OPEN_AIR_PADEL_COURT

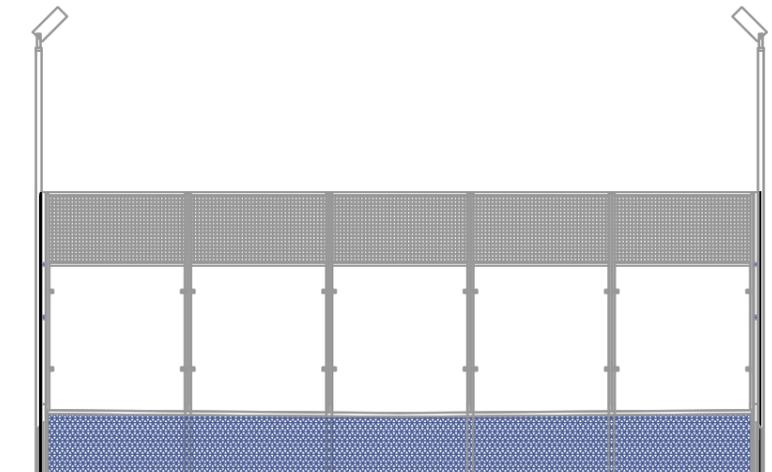
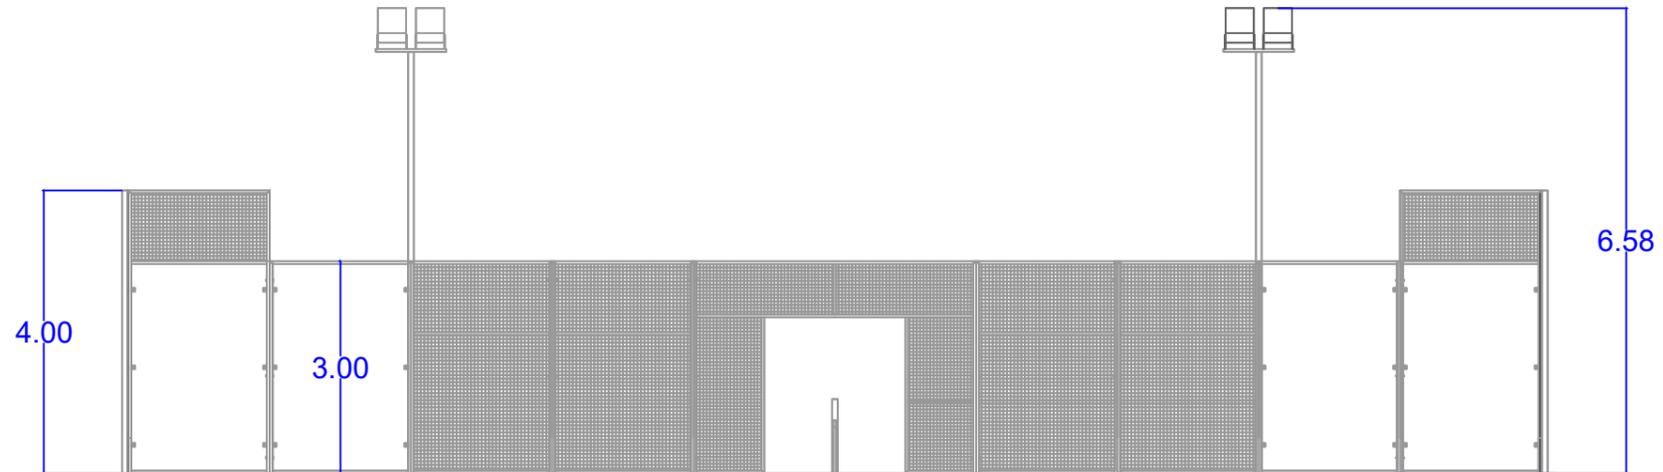
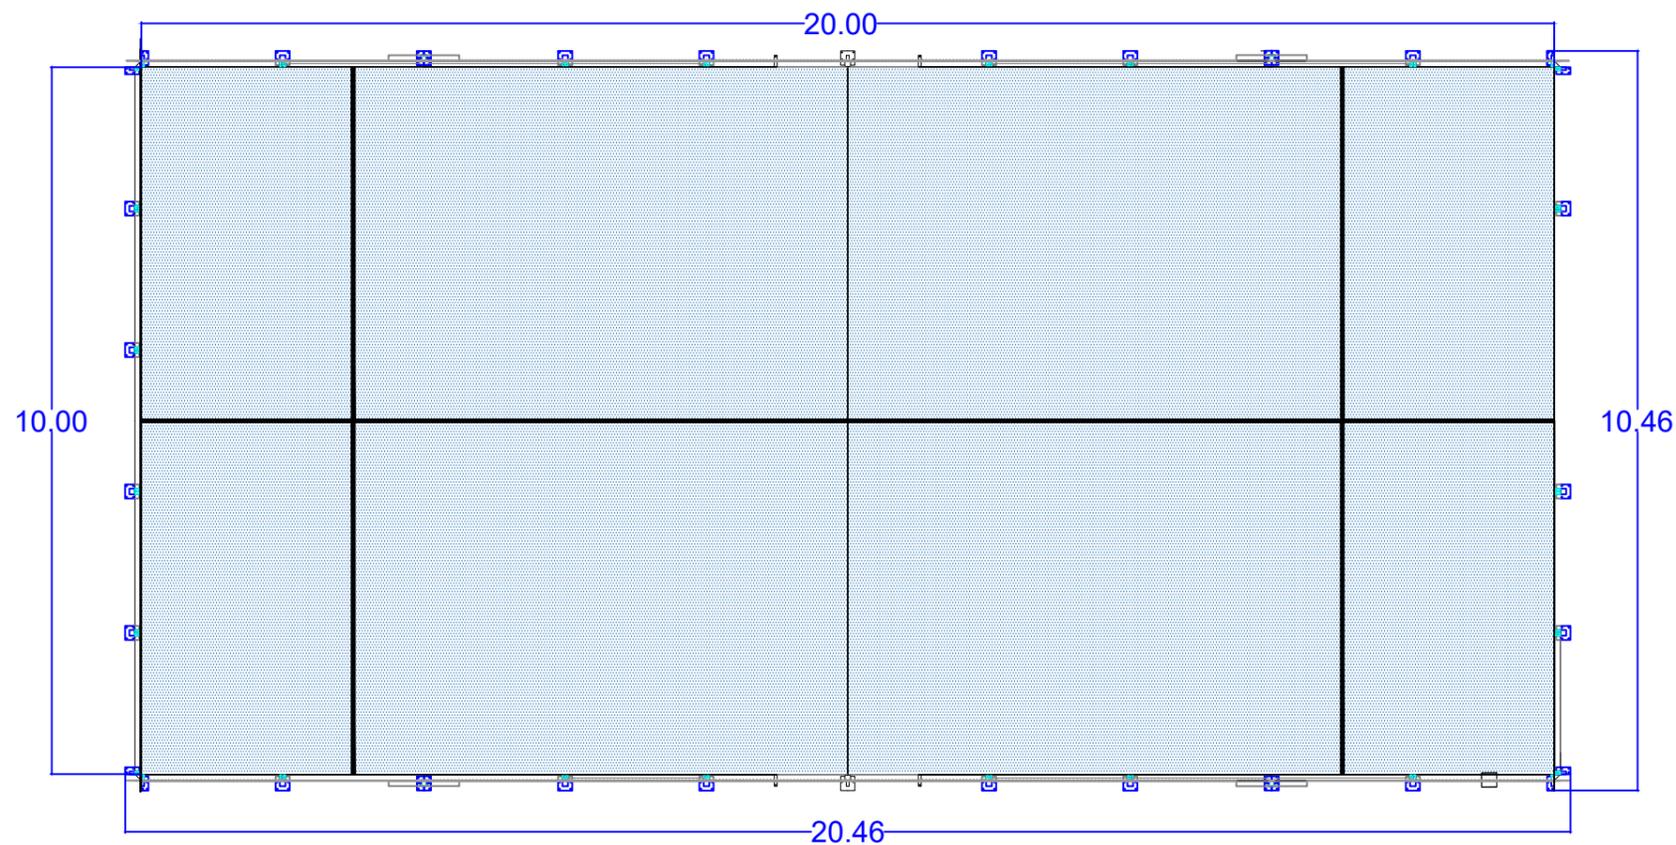
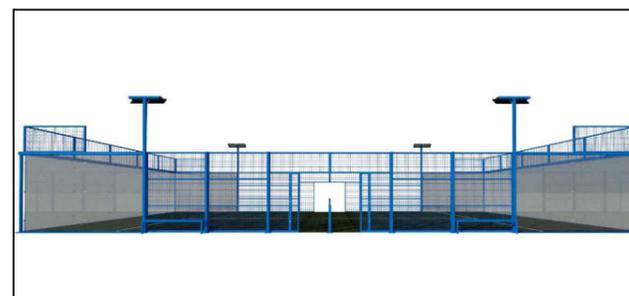
3) The creation of an open air Padel Tennis court will cause an increase in noise disturbance for local residents, on both sides of Huddersfield road and, as the Tennis Club is in a valley, the wider areas along Miry Lane.

There are no plans to show how the noise will be mitigated/ reduced.

Project No.	Scale	Drawing No.	Revision
LAD_563		PPF-01	REV_1

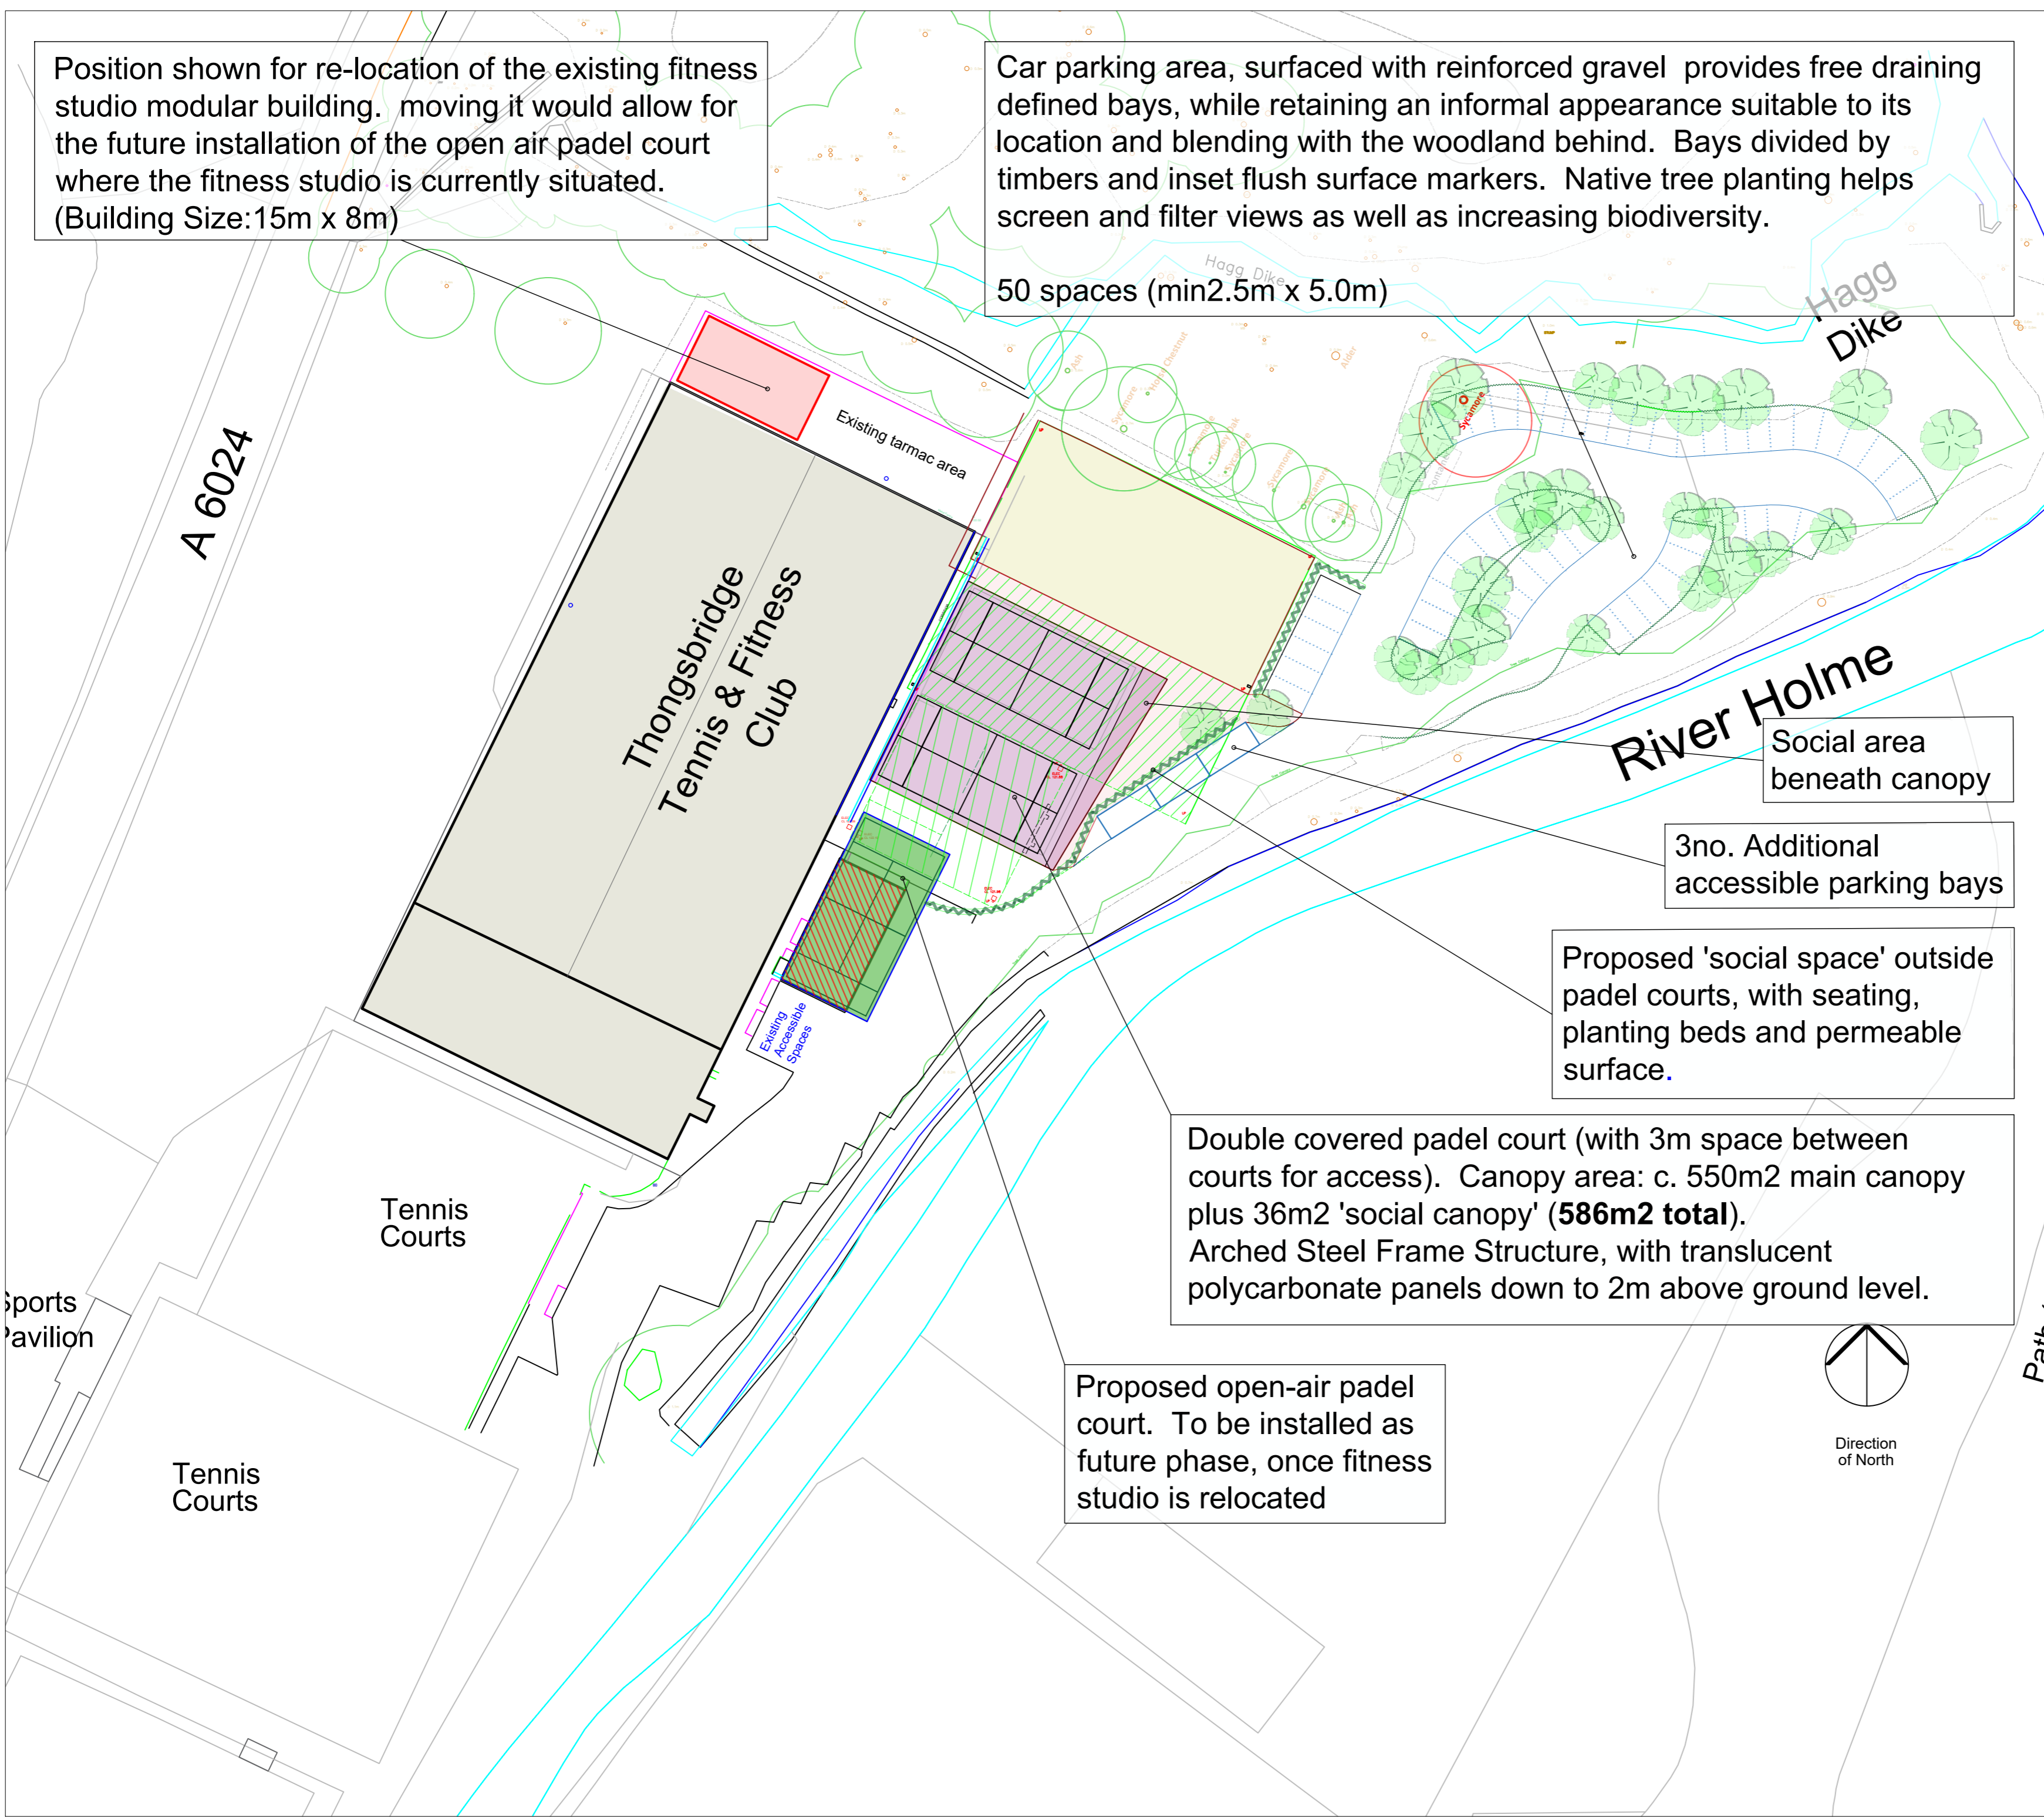
1) The area highlighted in the plan for work to be completed on extends through the existing carpark and up the road towards Miry Lane. However, there are no details in the plan of what work is to be carried out here or the impact this will have on the 4 residential properties which boarder the road.

Initial concerns are how access to and from the properties will be effected both during the implied works and after.

2) The increase in car parking appears to have been planned to accommodate an increase in traffic. As previous comments have mentioned, the junction joining Miry Lane is already treacherous and is only made worse by current members speeding into and out of the junction, regularly cutting corners, leaving a queue of traffic and driving down the wrong side of the road to gain access to the tennis club, without any concern for other vehicles or pedestrians, including school children.

There are no details within the plan to indicate how the welfare of other users has been considered.

As an additional point; the area highlighted in the plans as belonging to the applicant differs from land registry records.
